**Field Report**

**Project:** Pearl Place  
**Project #:** 1605  
**Date/Time:** 2/6/07-2:40 PM to 3:30 PM  
**Observers** Michael Cyr

**Building 2:**

BUILDING 2 - RETAINING WALL
SECTION 3
1/2"=1'-0"

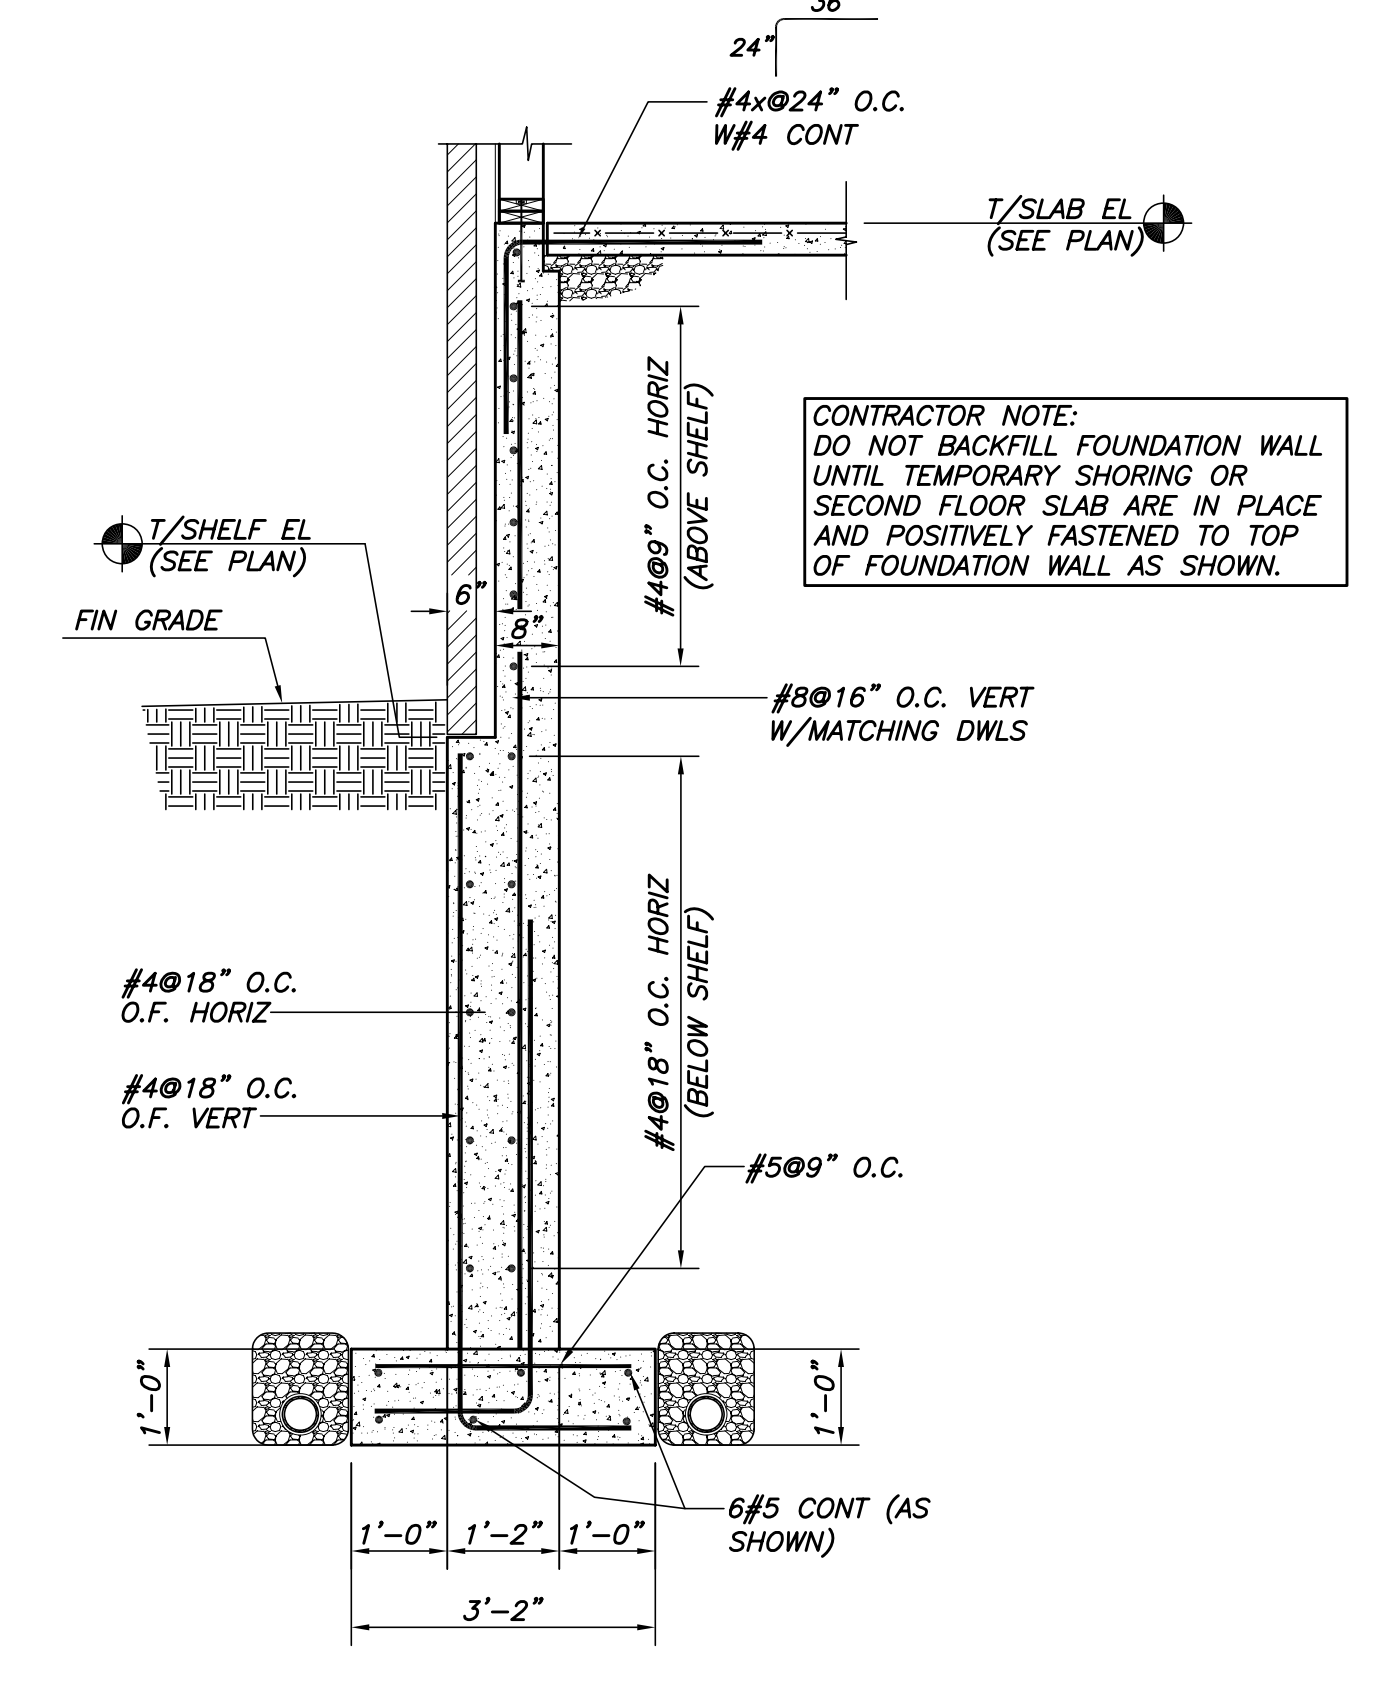
The wall dowels for the interior retaining wall parallel to Oxford Street have been correctly placed within the wall (Reference site visit 2007/02/01).
